PROJECT NUMBER: PR-2022-007327

Re: Preliminary Plat Review for Proposed Subdivision of Tracts A-1-A, A-1-B-1, A-1-B-2, and A-1-B-3-A of Acme Acres, with dedication of additional right-of-way to Cutler Avenue NE, and vacation of easements

Cartesian Surveys is acting as an agent for Consensus Planning, and we request a preliminary plat review to create four (4) new tracts from four (4) existing tracts and dedicate additional right of way to Cutler Avenue NE by lot line adjustment of Tracts A-1-A, A-1-B-1, A-1-B-2, and A-1-B-3-A of Acme Acres. The property is currently zoned as MX-H (Mixed-Use – High Intensity) and NR-C (Non-Residential Commercial) for just Tract A-1-B-3-A. The property also looks to vacate 2 easements on behalf of AMAFCA, and portions of easements within the proposed dedication of right-of-way for Cutler. A sketch plat review for this project was heard under PR-2022-007327 on July 20, 2022. The comments from that hearing are provided below:

**Site Sketch for  
Tracts A-1-A-1, A-1-B-1-A,  
A-1-B-2-A and A-1-B-3-A-1  
Acme Acres  
Being Comprised of  
Tracts A-1-A, A-1-B-1, A-1-B-2  
and A-1-B-3-A, Acme Acres  
City of Albuquerque  
Bernalillo County, New Mexico  
November 2022**

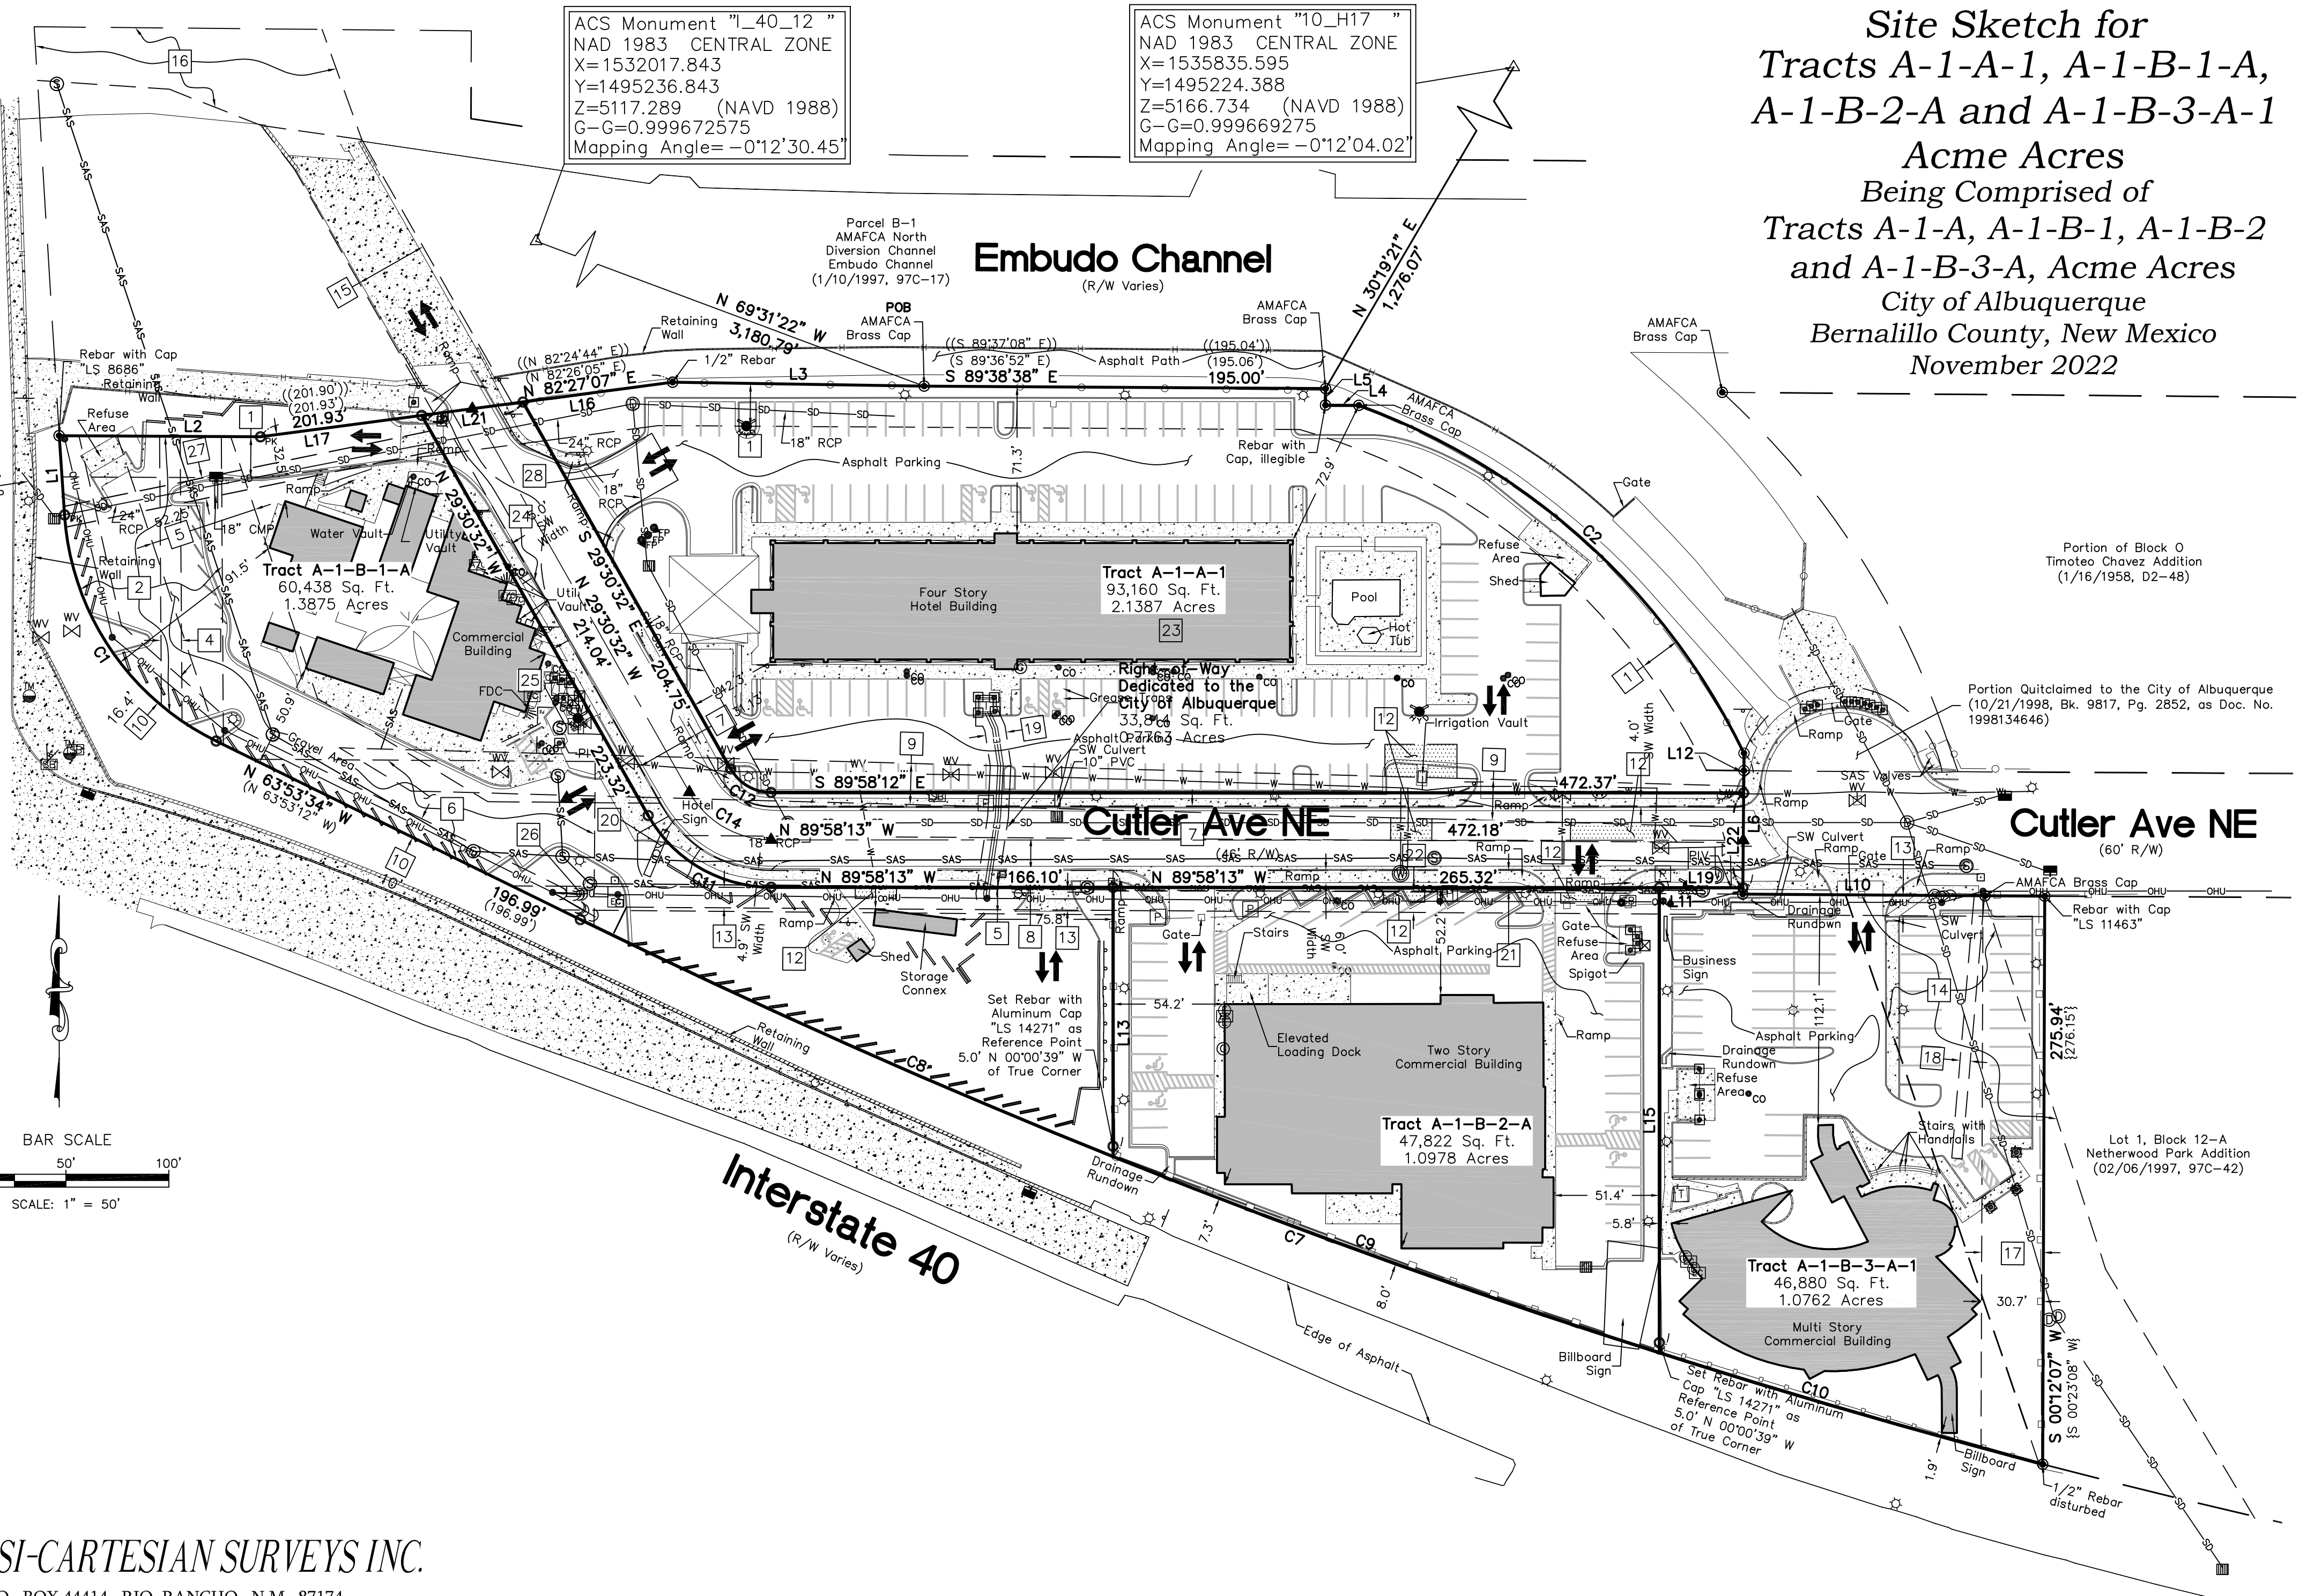
2. There appears to be a structure within the public water public sewer easement (5) on the Green Jeans parcel. Please verify. If a structure is within this easement it would typically require removing the structure.

a. There appears to be an encroachment on a public sewer main. If necessary, resolution to the encroachment may require an infrastructure list item.

1. Please provide a cross section of Cutler showing sidewalk, curb and gutter and proposed ROW.
2. Please provide details of the existing access points to the hotel and surrounding businesses.

Noted, structure into easement [5] is a refrigeration container and can be moved upon request.

Noted, hotel sign within easement 20, is further than simplified SAS linework appears. The 811 spotting puts the SAS main 2 feet further south of the sign than is shown. There is still coincidence of easements [5] and [20] in this location, but overlap may not be as severe as the site sketch shows.

Noted, see attached exhibit for cross section of roadway and site sketch for entrance / street access labels.
